Subject: 70 Anderson Street Redevelopment
Comment Response Letter

Shukria Wiar – Memorandum to Portland Planning Board 7/18/16

FOUNDATION DRAIN DETAIL  
NOT TO SCALE

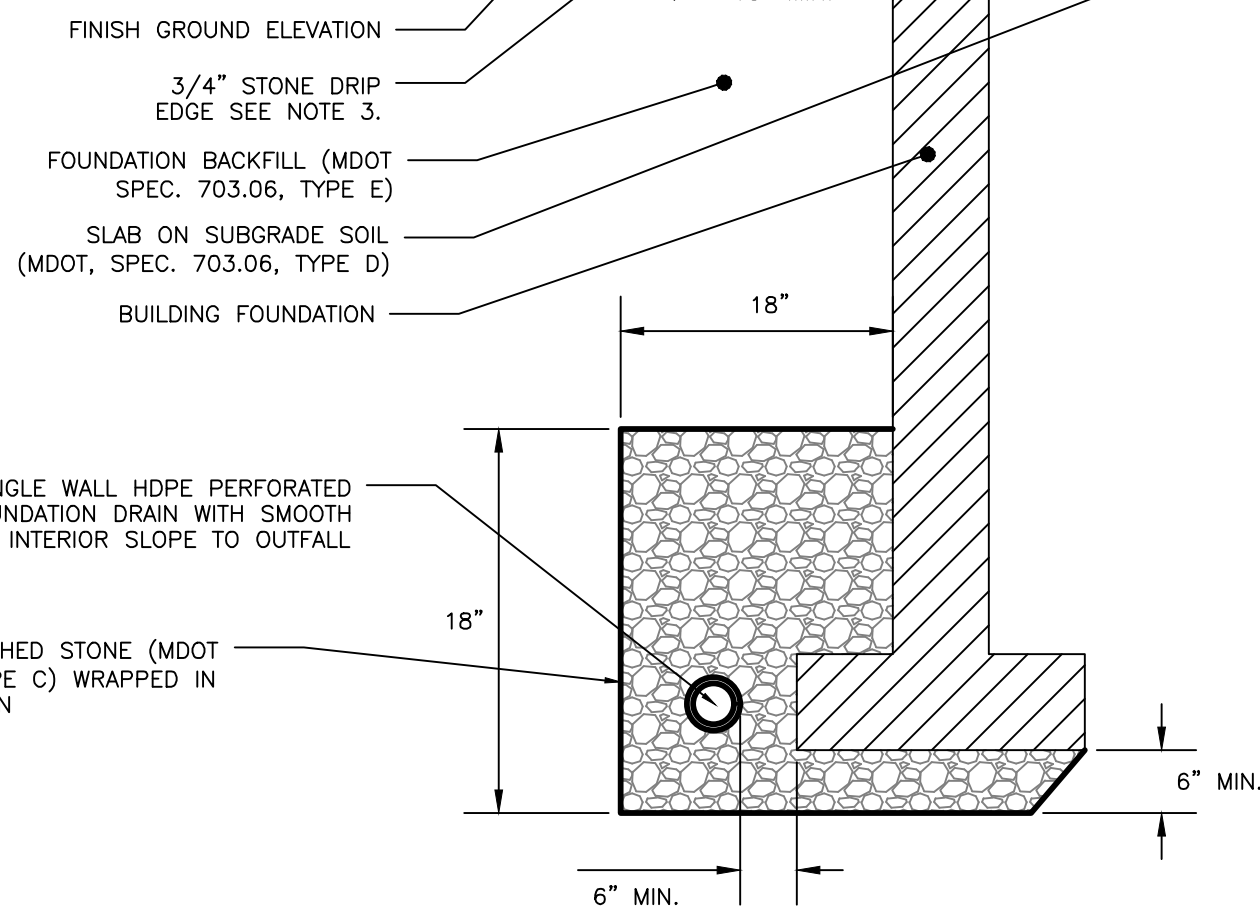
Comment – *The plans show a foundation drain with connected in-line drains around the southern-most building. The Applicant should clarify where this system will discharge.*

Response – The foundation drain has been revised to show a connection to the rain garden outlet prior to entering the existing municipal stormwater drain within Anderson Street.

RAIN GARDEN DETAIL  
NOT TO SCALE

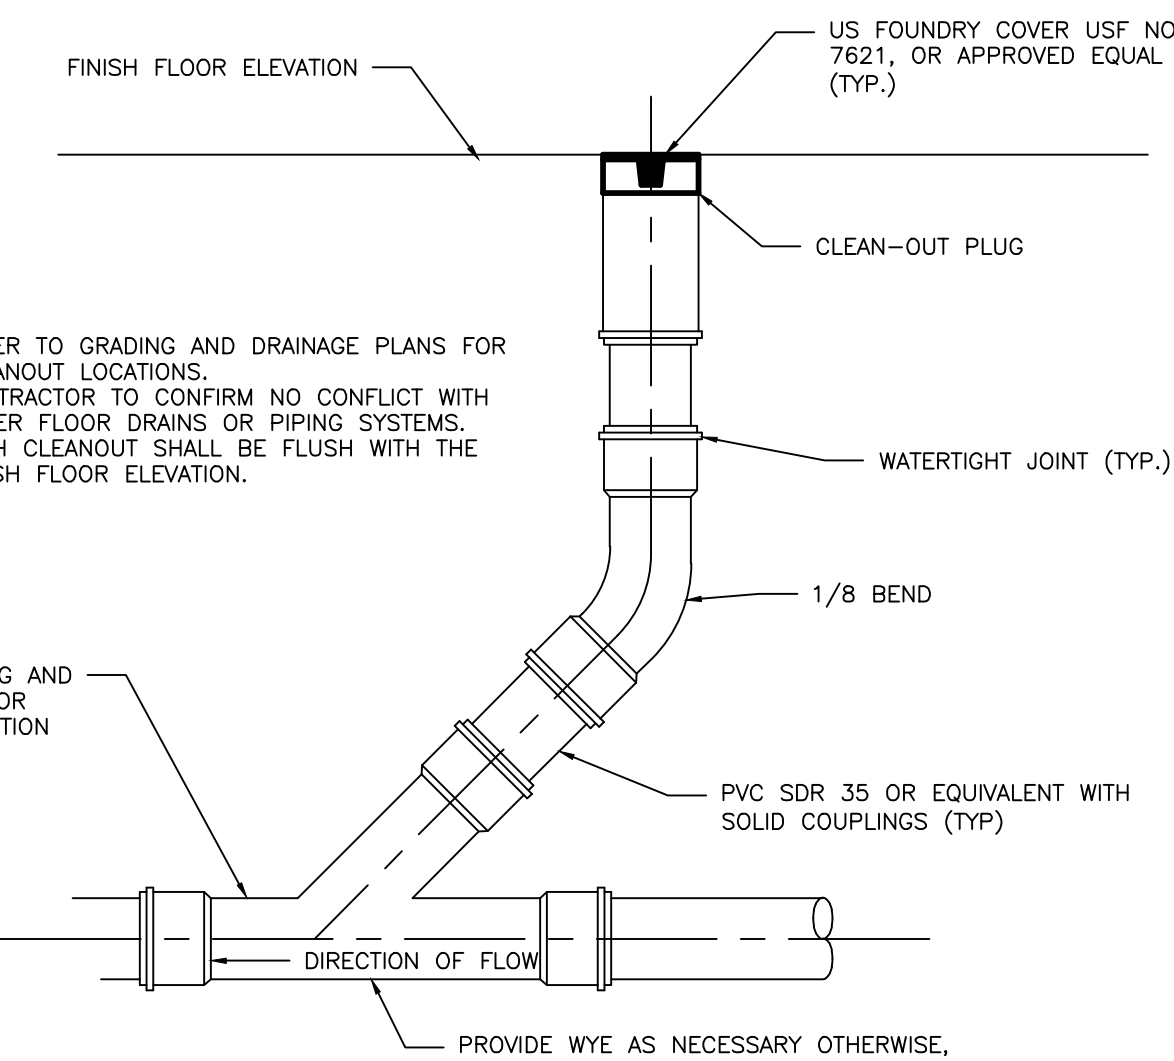
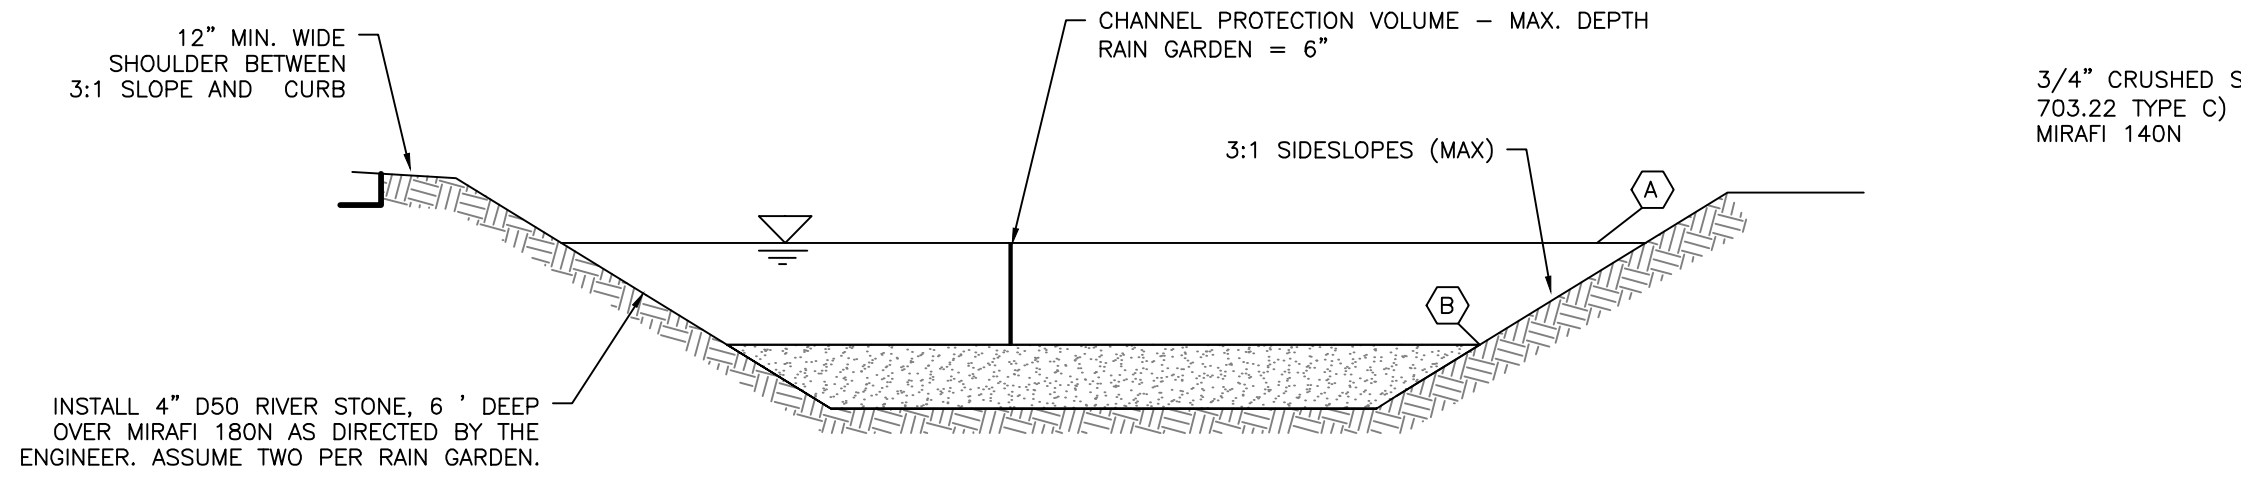
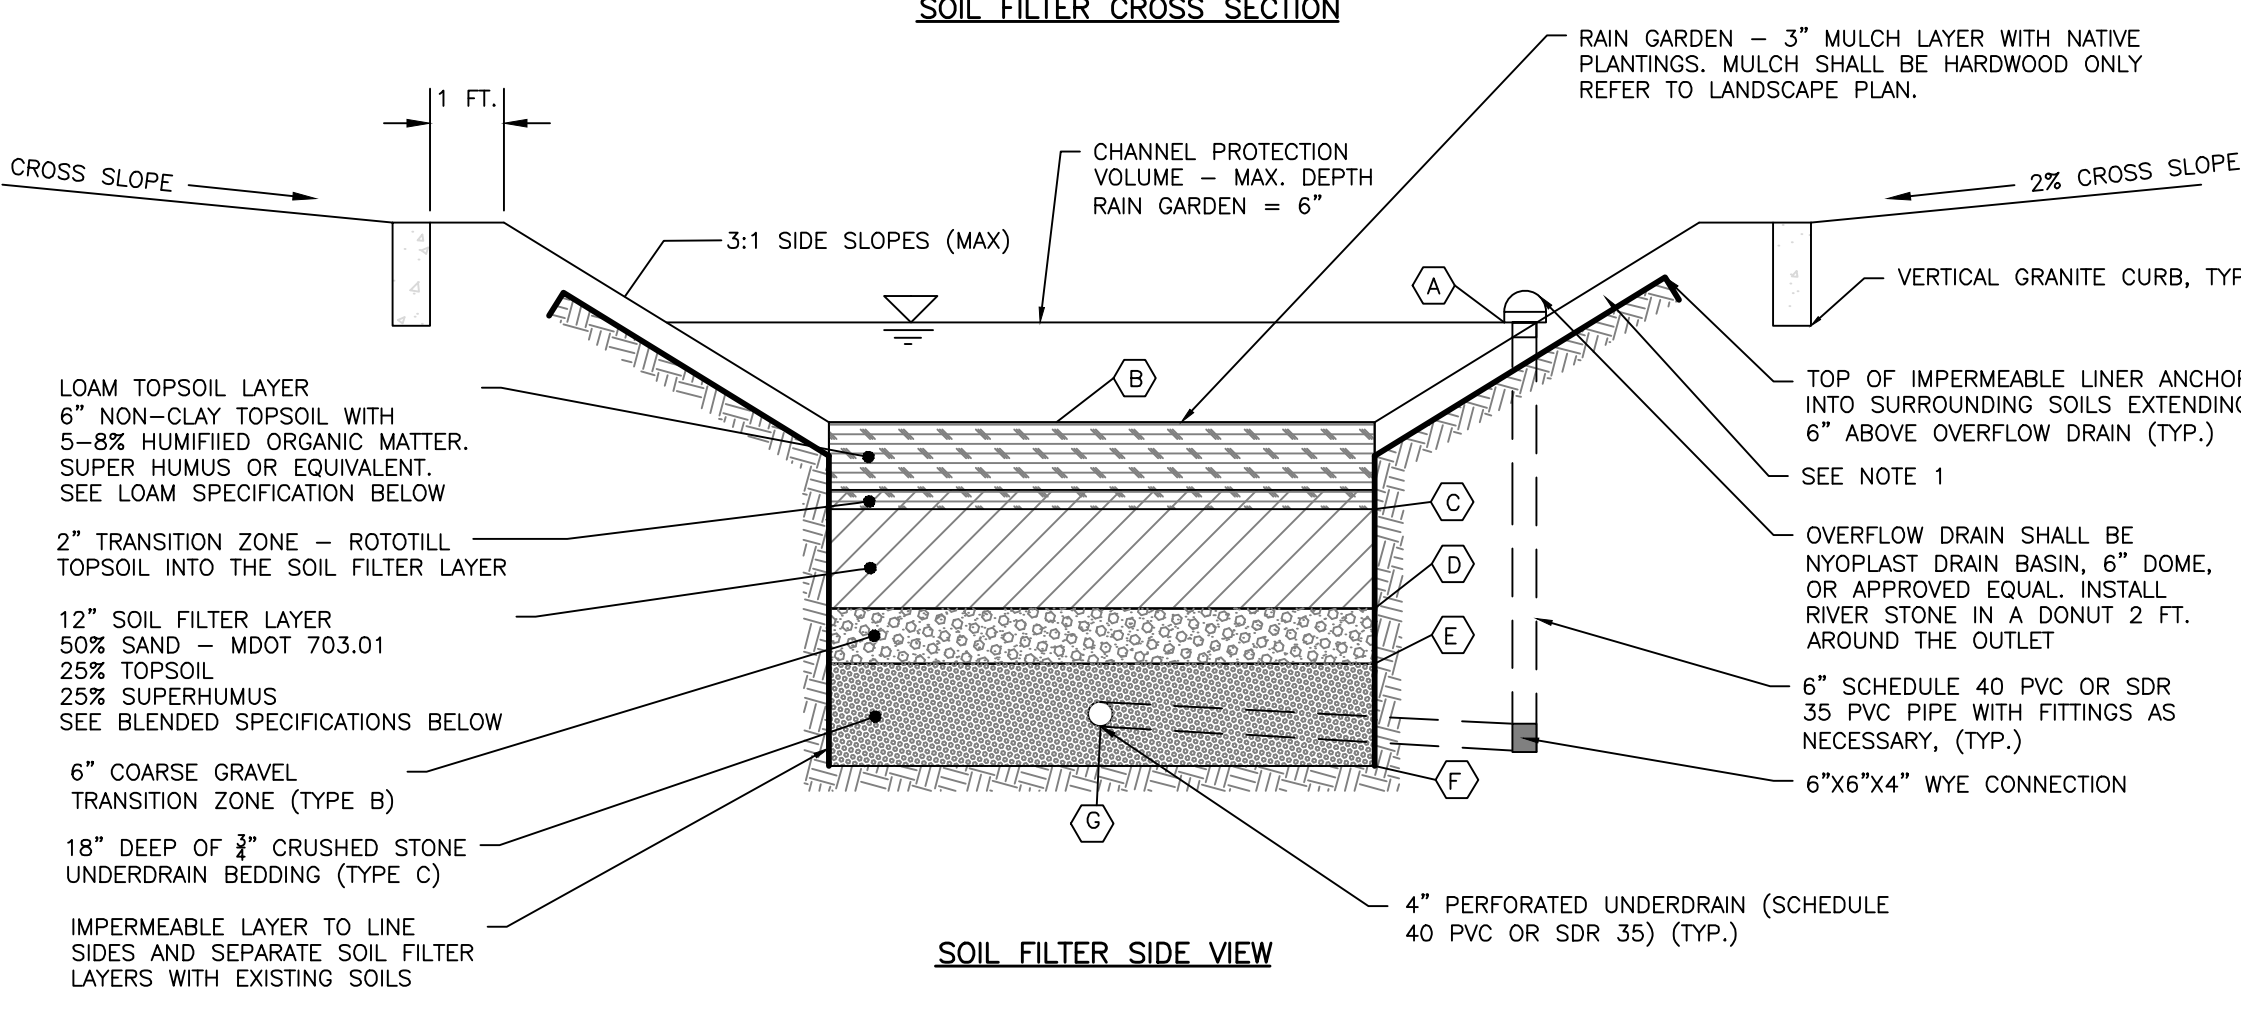
- b. *The Applicant should clarify the exfiltration invert included in the model for the rain garden. The elevation doesn't match the base elevation of the rain garden.*

- c. *The Applicant has noted that a vertical orifice/grate has been modeled for both the rain garden and the roof drip edge outlet to provide for 24-hour stormwater detention. This orifice is not identified on the plans.*

- b. The values were revised; the exfiltration invert now matches the base of the rain garden.
 - c. From the revised Stormwater Report, "A simulation water quality outlet (vertical orifice) is modeled to mimic the minimum 24-hour release time through the soil filter media. This is completed by adjusting the rainfall amount in HydroCAD until the inflow volume is equal to or greater than the calculated treatment volume. The storm events are modeled as type III, 24-hour storm events in HydroCAD.

A vertical orifice is then modeled in HydroCAD at the outlet structures of each BMP. The simulation orifice diameter is sized to mimic the percolation rate through the soil filter media, a physical orifice is not proposed.” Given the small size of the tributary area we believe a traditional outlet control structure is unnecessary.

**L1.0**

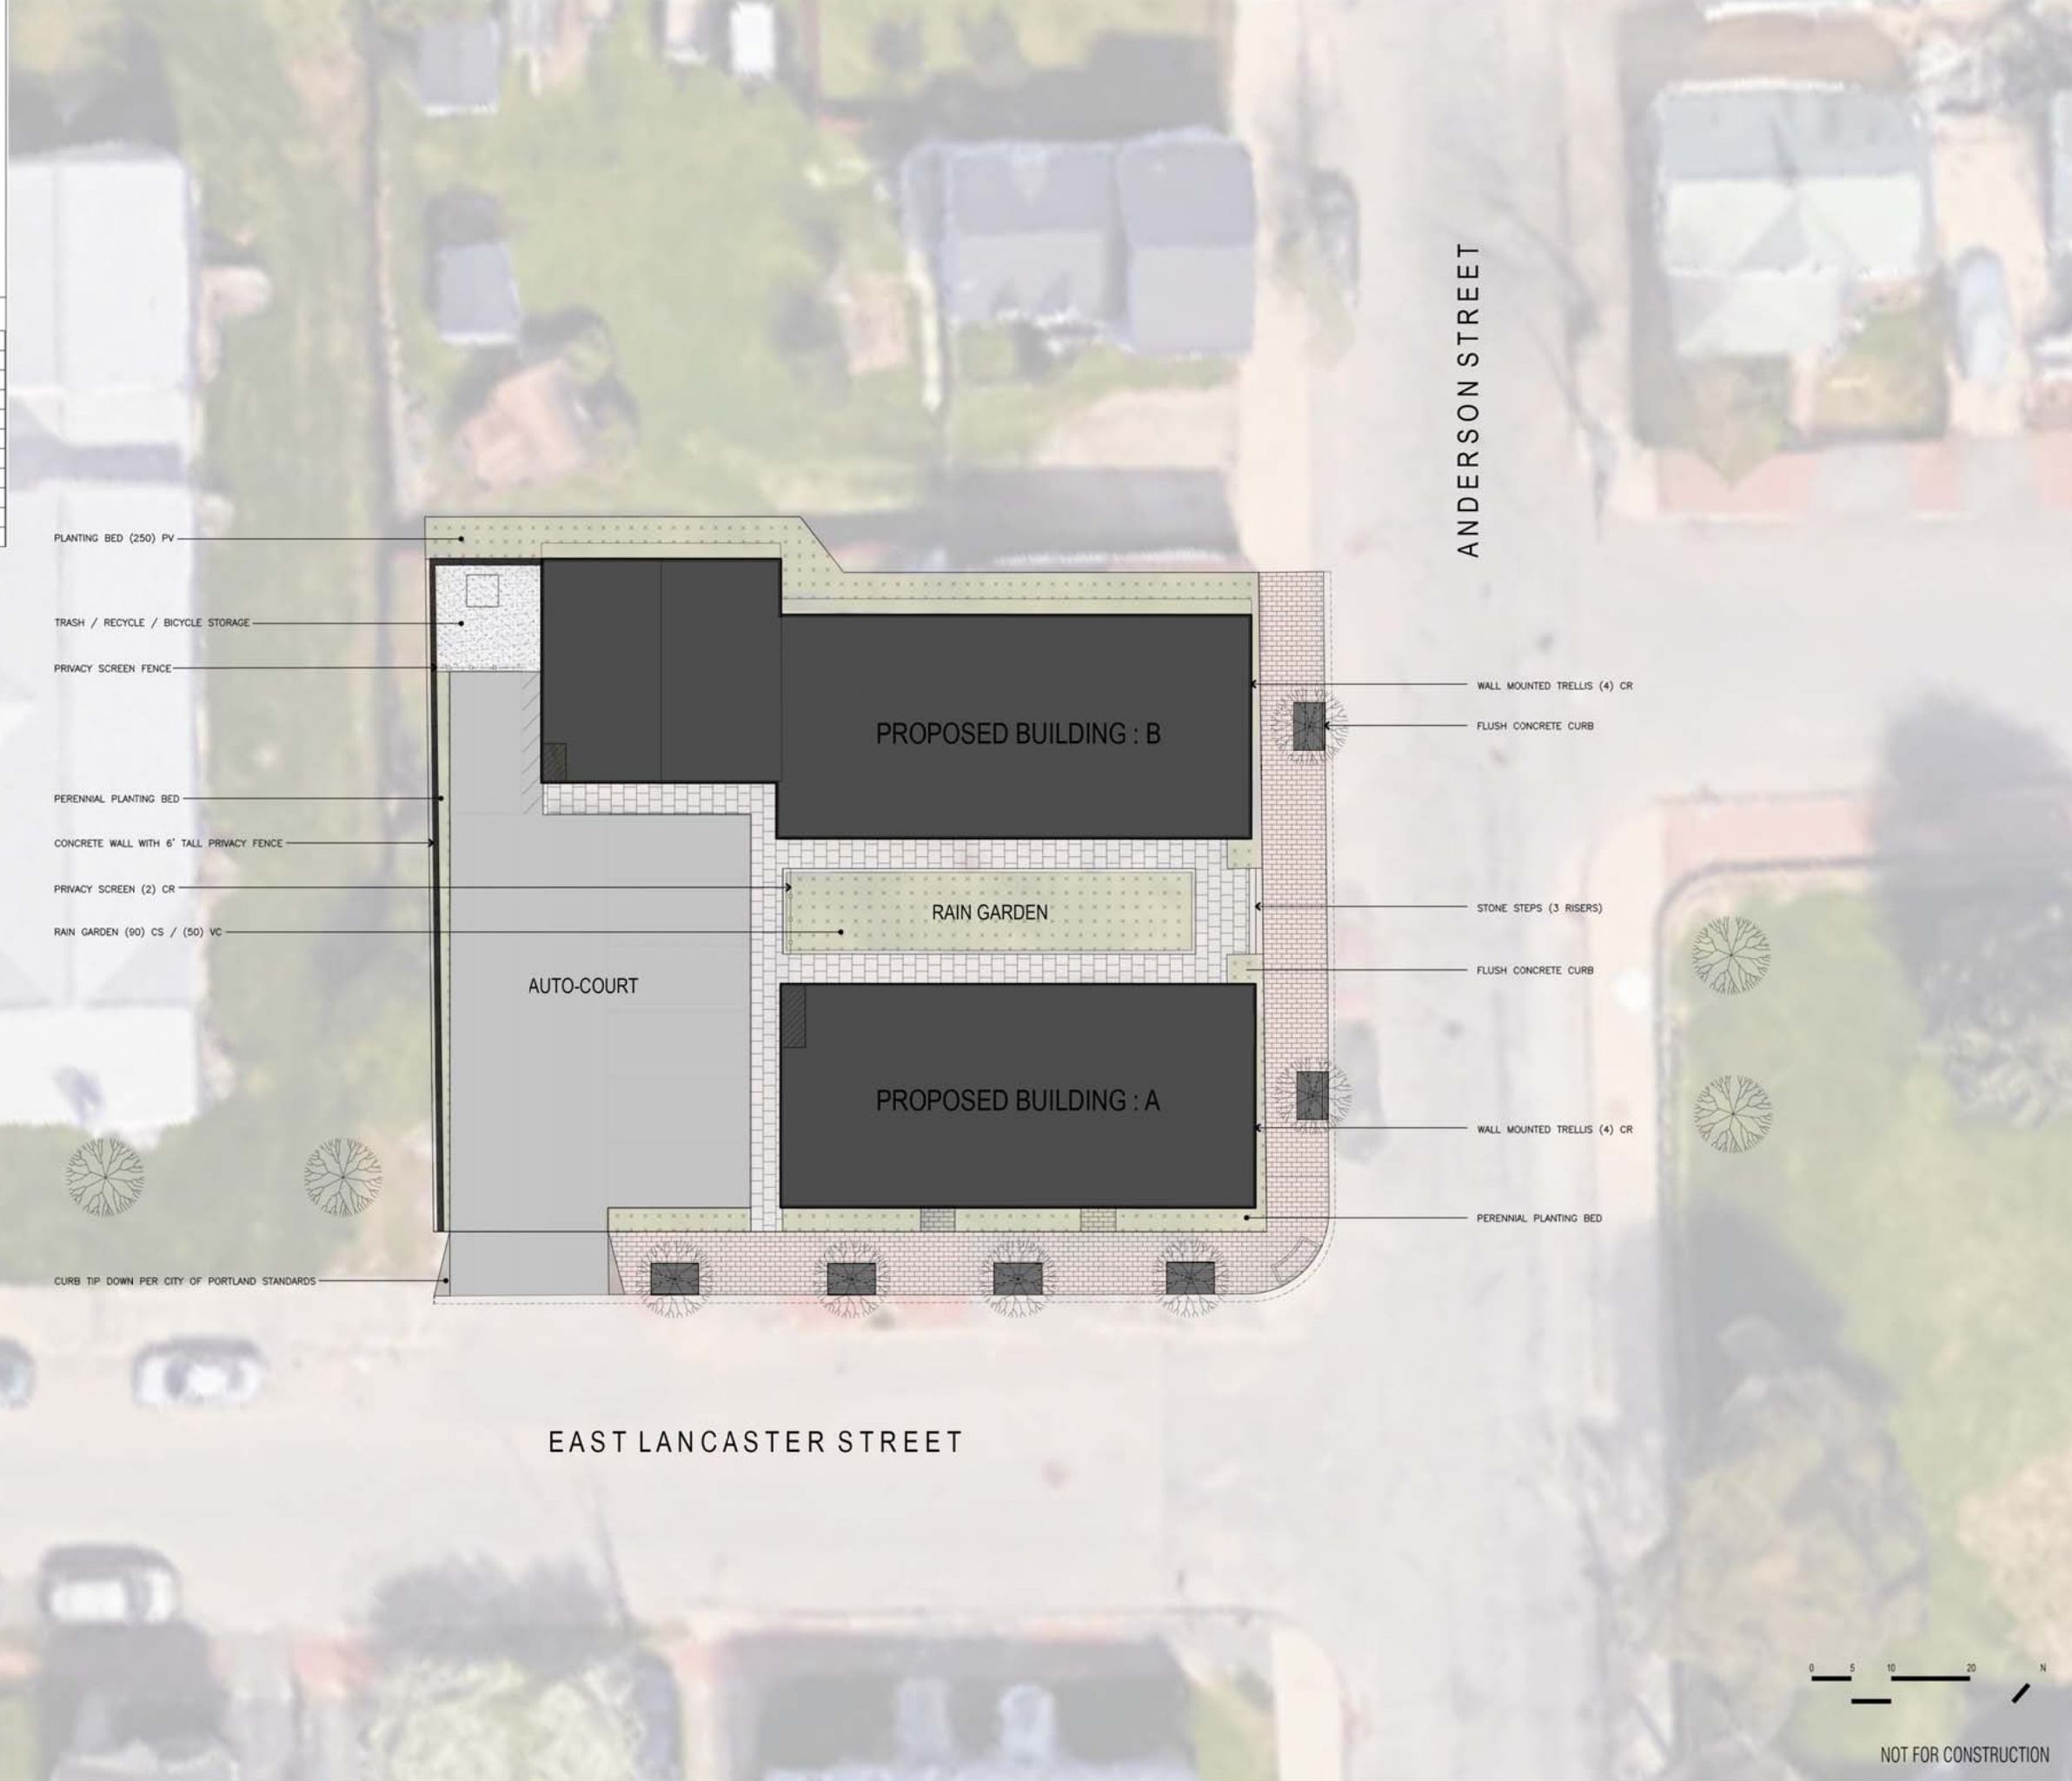
Comment – *Street trees: Extend the street tree planting to include Lancaster Street as well as Anderson Street. After taking a closer look the space is too tight or restrictive to include two trees in the tree planters.*

Comment -- *Tree planters should not be raised due to on street parking, they should be rectangular in shape 4' x 7' ideal.*

Comment -- *Landscape treatment should be considered for the area near the parking lot.*

Comment -- *Ornamental grasses proposed for the 5' border is acceptable, applicant may want to consider alternatives, woody plants or herbaceous plant material / perennials that offer flowers / texture and year-round interest.*

Response – The street trees are to be revised to reflect one tree per planter and also be proposed along East Lancaster Street. The Final Landscape Plan defines the planter location, size, and species.

Response – Street trees are revised to be planted in 4'X6' metal tree grates flush with the surrounding sidewalk. The flush grates will be used to maintain a minimum 5' pedestrian accessible route within the sidewalk.

Response – Landscaping will be provided in two areas bordering the parking lot along the East Lancaster Street property frontage and along the retaining wall and cedar fence. Please refer to the revised Landscape Plan.

Response – Please refer to the revised Landscape Plan.
